RE: Staff Review Comments for Level II Preliminary Site Plan

Project Name: TruChoice Federal Credit Union Improvements
Address: 272 Park Avenue
Applicant: TruChoice Federal Credit Union
Planner: Nell Donaldson

Project ID: 2012-606
CBL: 65-E-4

GRADING AND UTILITY PLAN  
 OF:  
**TRU CHOICE FEDERAL CREDIT UNION**  
 777 PARK AVENUE  
 PORTLAND, MAINE  
 FOR:  
**TRU CHOICE FEDERAL CREDIT UNION**  
 777 PARK AVENUE  
 PORTLAND, MAINE 04101

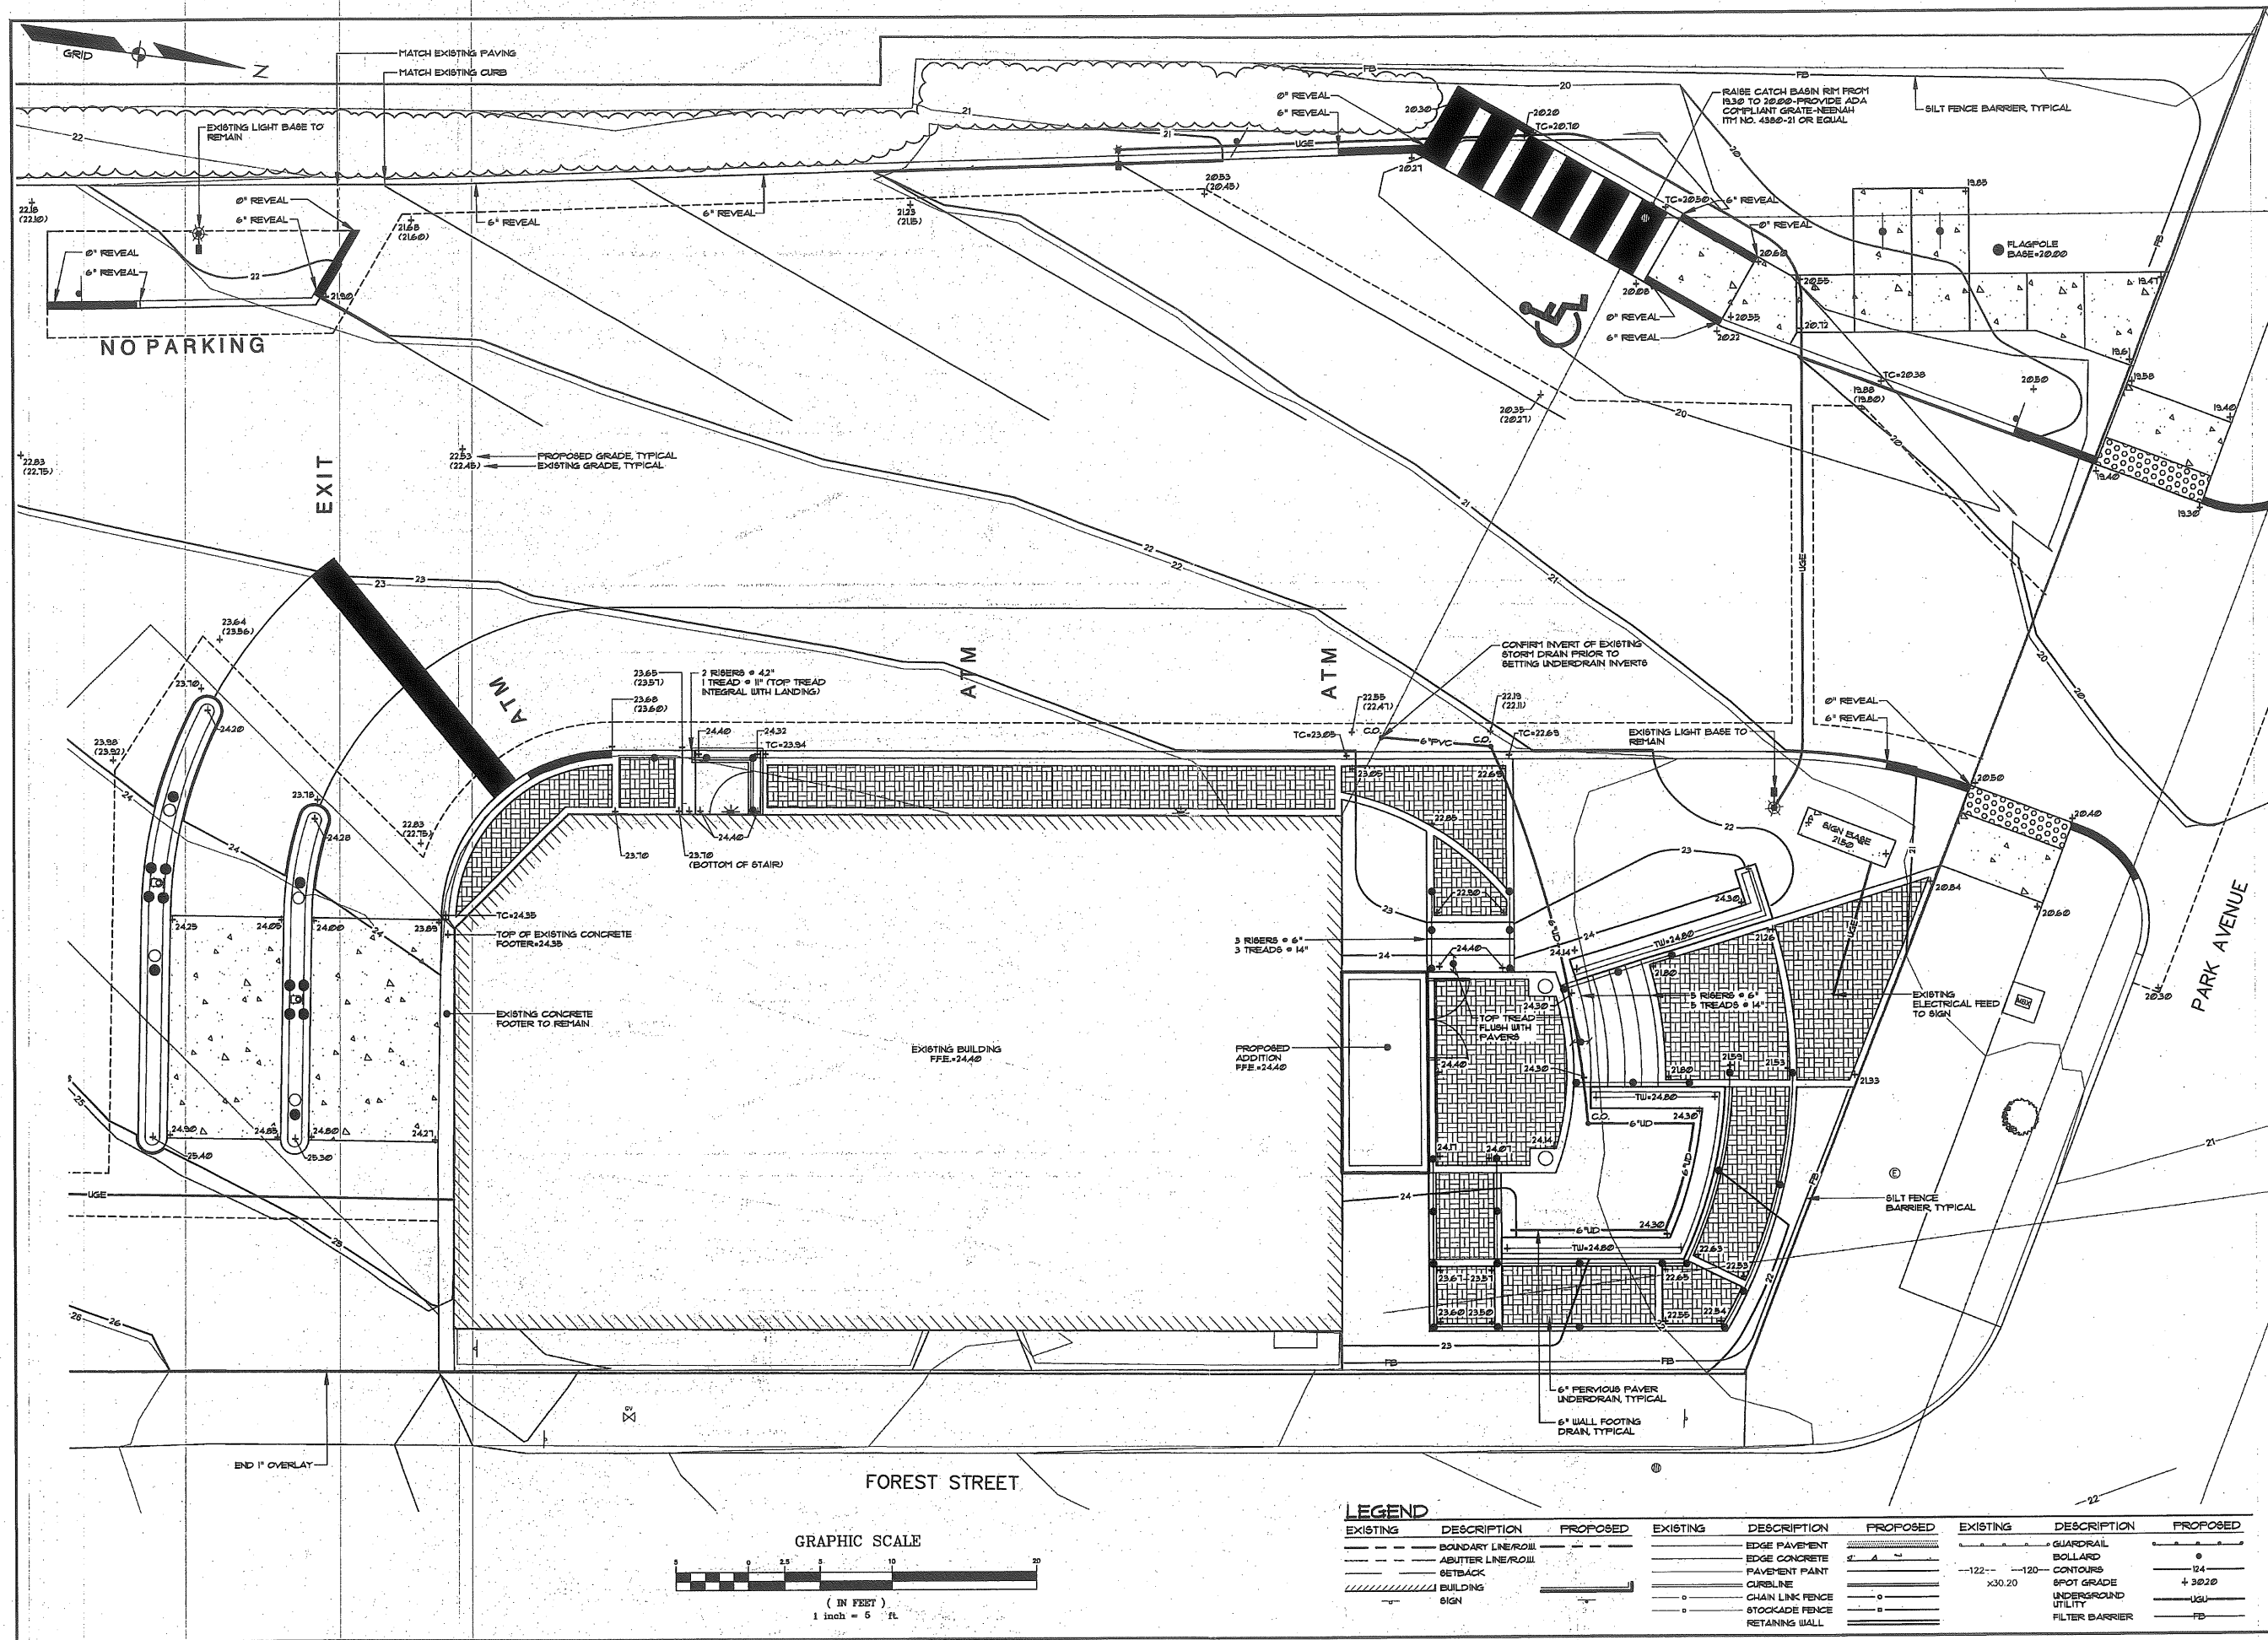
The applicant proposes to add an ADA accessible parking space with an adjacent access aisle, curb ramp, and sidewalk at the northwest corner of the site. This area is an existing low point with a catch basin that collects drainage from the majority of the drive-lanes and parking areas of the site. The applicant proposes to raise the rim grade of the catch basin by approximately 0.7' and install an ADA compliant grate to allow access over the catch basin. We recommend that the applicant revisit the location of this ADA accessible lane and access route to not fall within a drainage collection location.
